## **Comments on the Applicant's Responses to the Examining Authority's Written Questions.**

Unique Reference Number: 20040614

On the 10<sup>th</sup> October 2023, I submitted my "Written Representation to the Examining Authority regarding the Environmental Statement submitted by Tritax Symmetry (Hinckley) Ltd in respect of their proposed Hinckley National Rail Freight Interchange and with particular reference to Chapter 10: Noise and vibration."

00:00 on 25/04/2021 to 00:00 on 26/04/2021

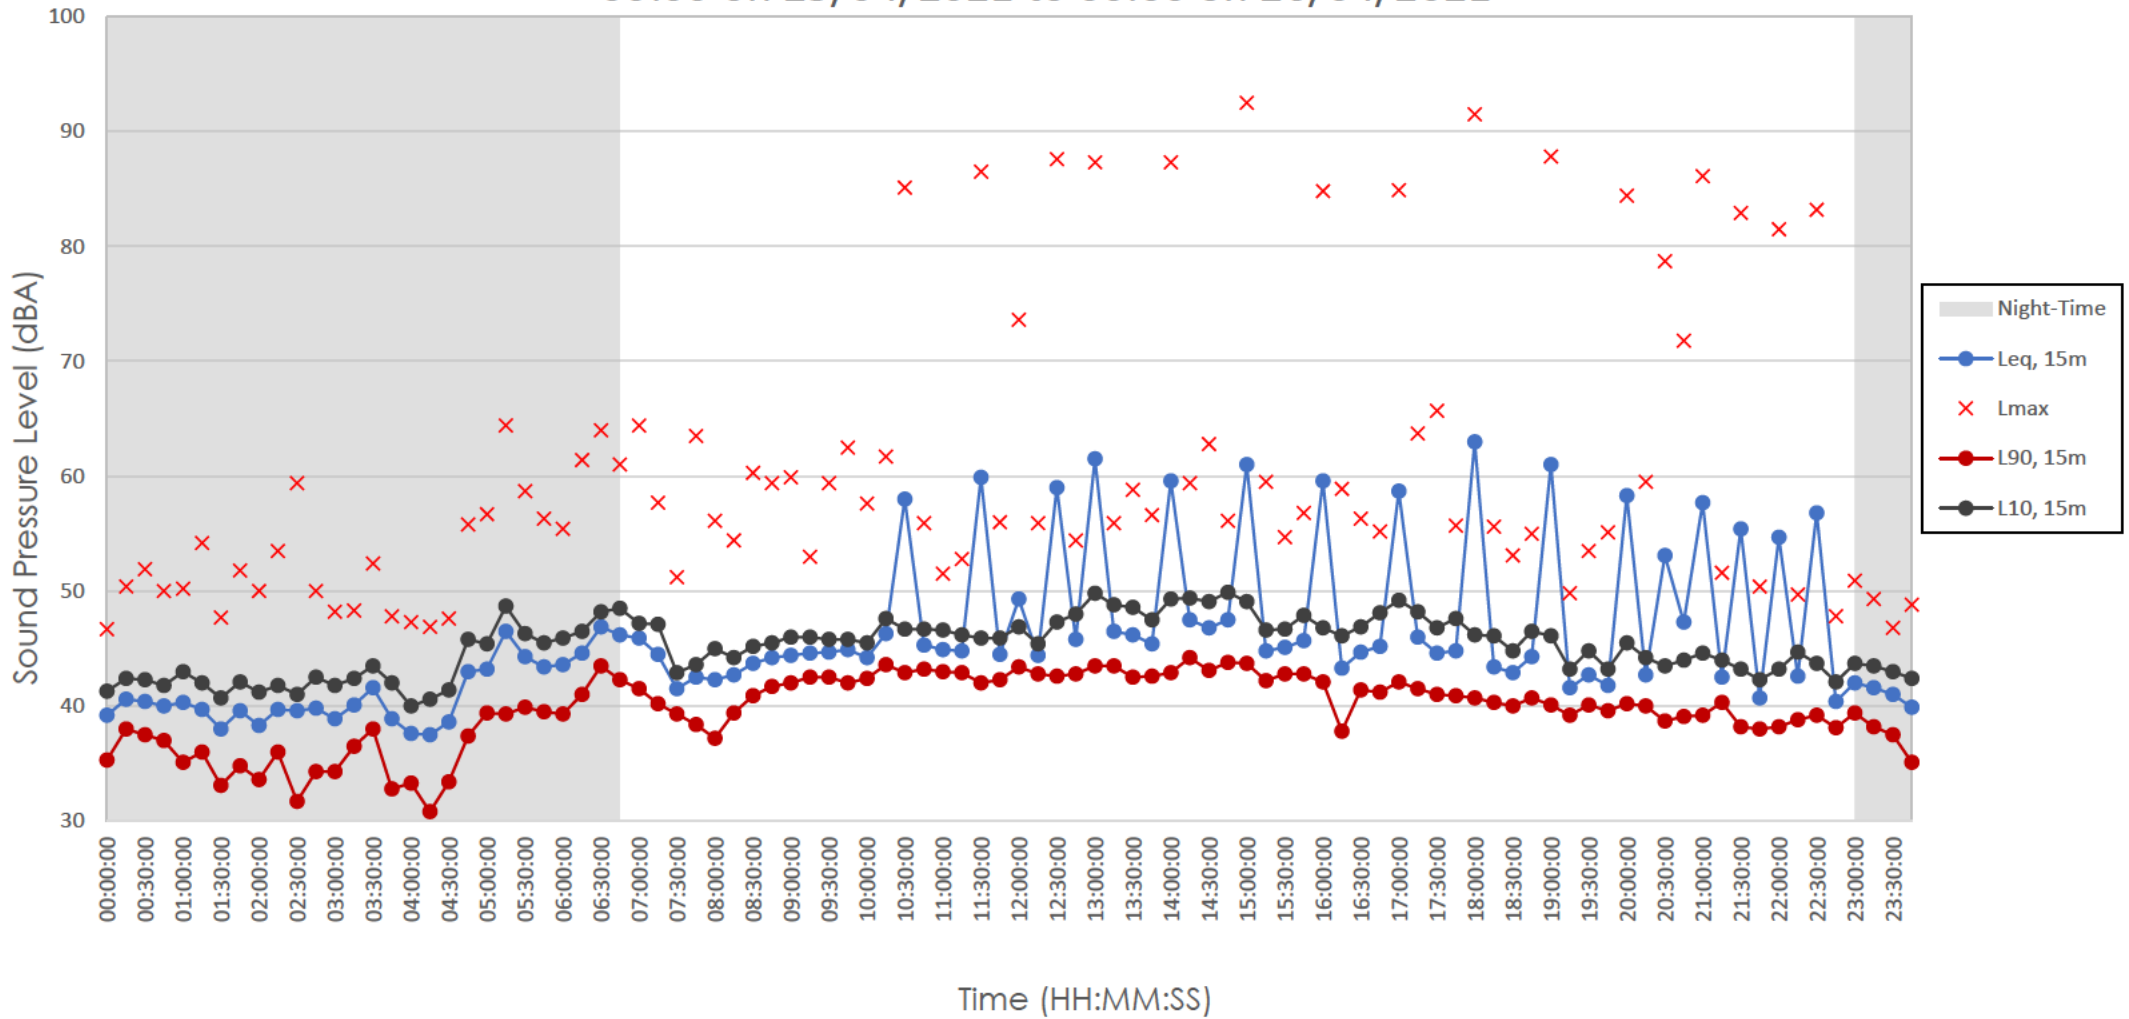
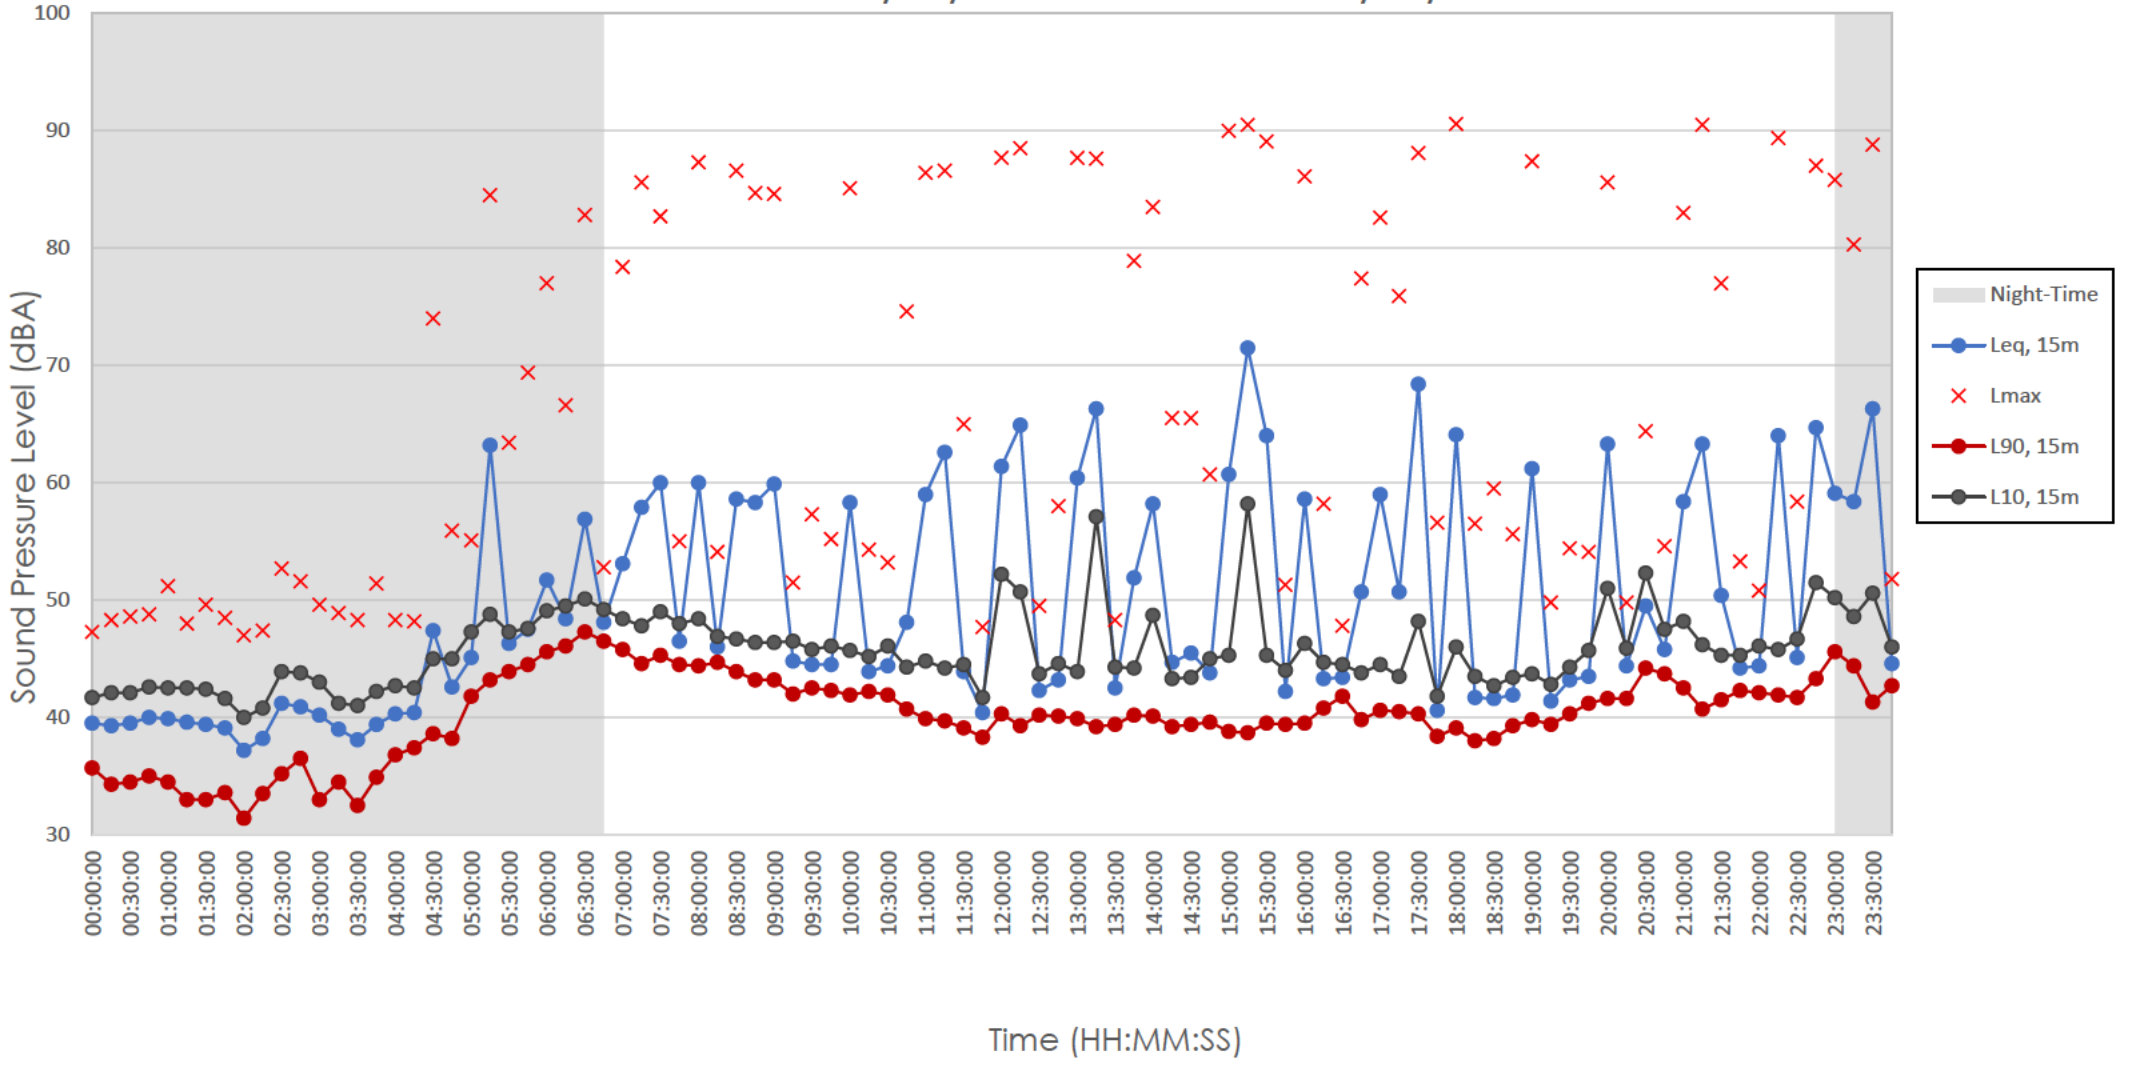
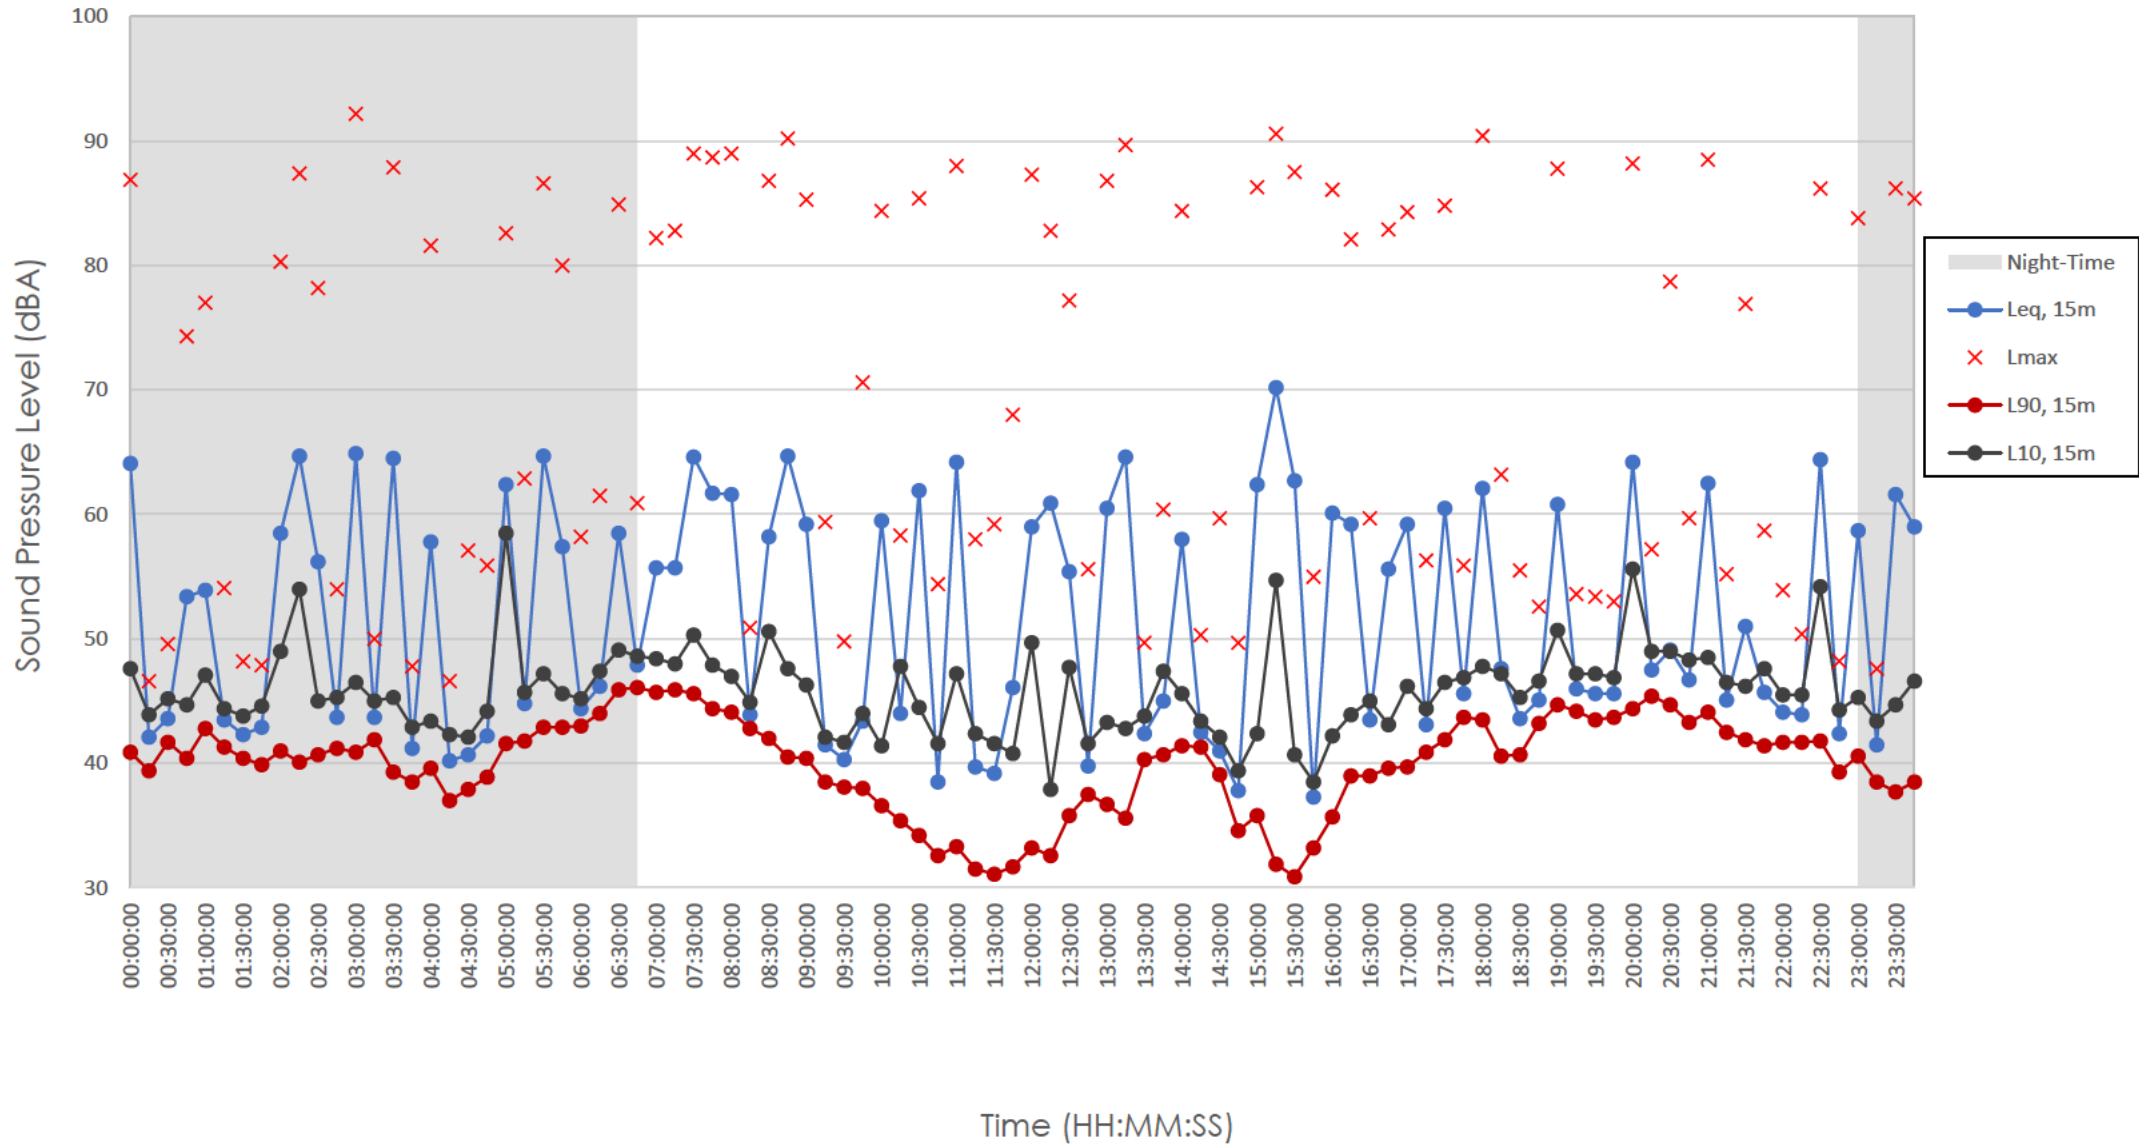
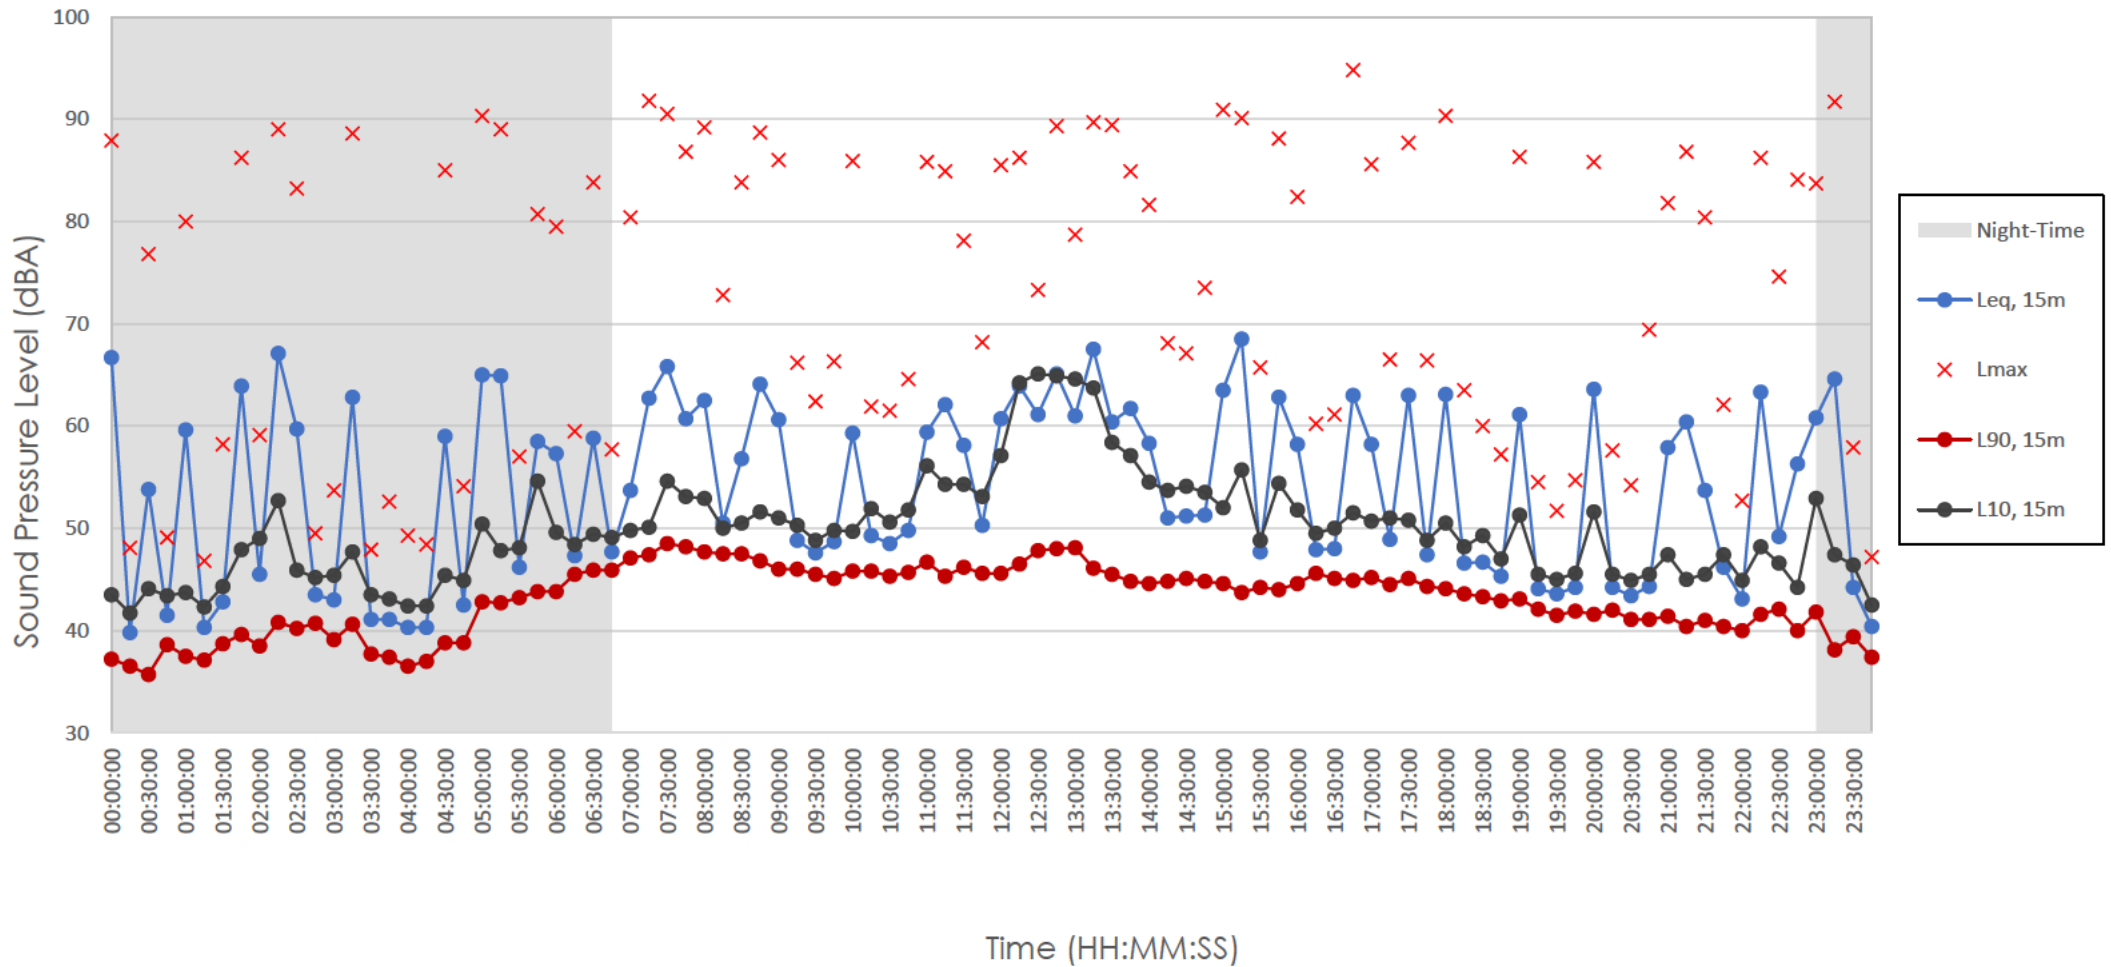
In their Noise and vibration report proper, Tritax measured Rail Noise at Noise Monitoring Position NMP4 at the trackside over a continuous period of some seven days. As such, that measured data may be viewed as the “Gold Standard” and together with the data from the other NMPs forms a foundation of Tritax’s report.

The Rail Noise data that Tritax seek to introduce in their Update Note is however ***very much higher*** than the NMP4 data Tritax measured in their Noise and vibration report.

But it’s when you actually come to look at the dB values in the Table Keys that the alarm bells really start to ring. For example, in Figure 2, the boundary between the orange and the yellow bands is indicated at 55.0dB. But this is almost the same night-time Noise level of 56.3dB that was measured at NMP4 at a location just 12 metres from the track!

Further analysis indicates that in comparison with the precise “Gold Standard” Noise measurements performed at NMP4 over a period of seven days, the data in Figures 1 and 2 overstates the Train Noise levels by approximately 12dB during the daytime, and rather more at night-time. So the values in the dB Keys in Tritax’s Figures 1 and 2 need to be adjusted downwards by 12dB accordingly.
